Application number: 2020/90784	
What is the application for?:	Alterations to convert part of existing newsagent into prayer facility
Address of the site or building:	260-262, Wakefield Road, Earlsheaton, Dewsbury, WF12 8AN
Postcode:	WF12 8AN

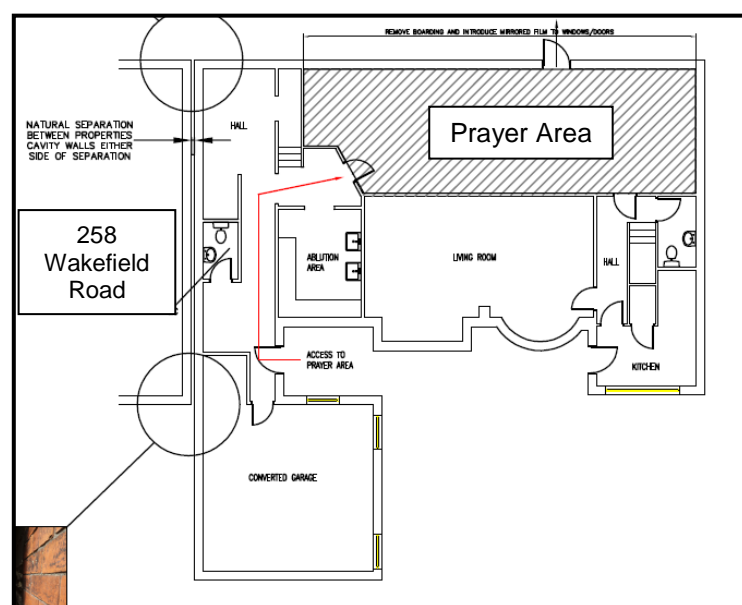
Type of comment: An objection
This is a very busy crossing particularly during rush hour and there is insufficient parking for a facility which would hold a large number of people
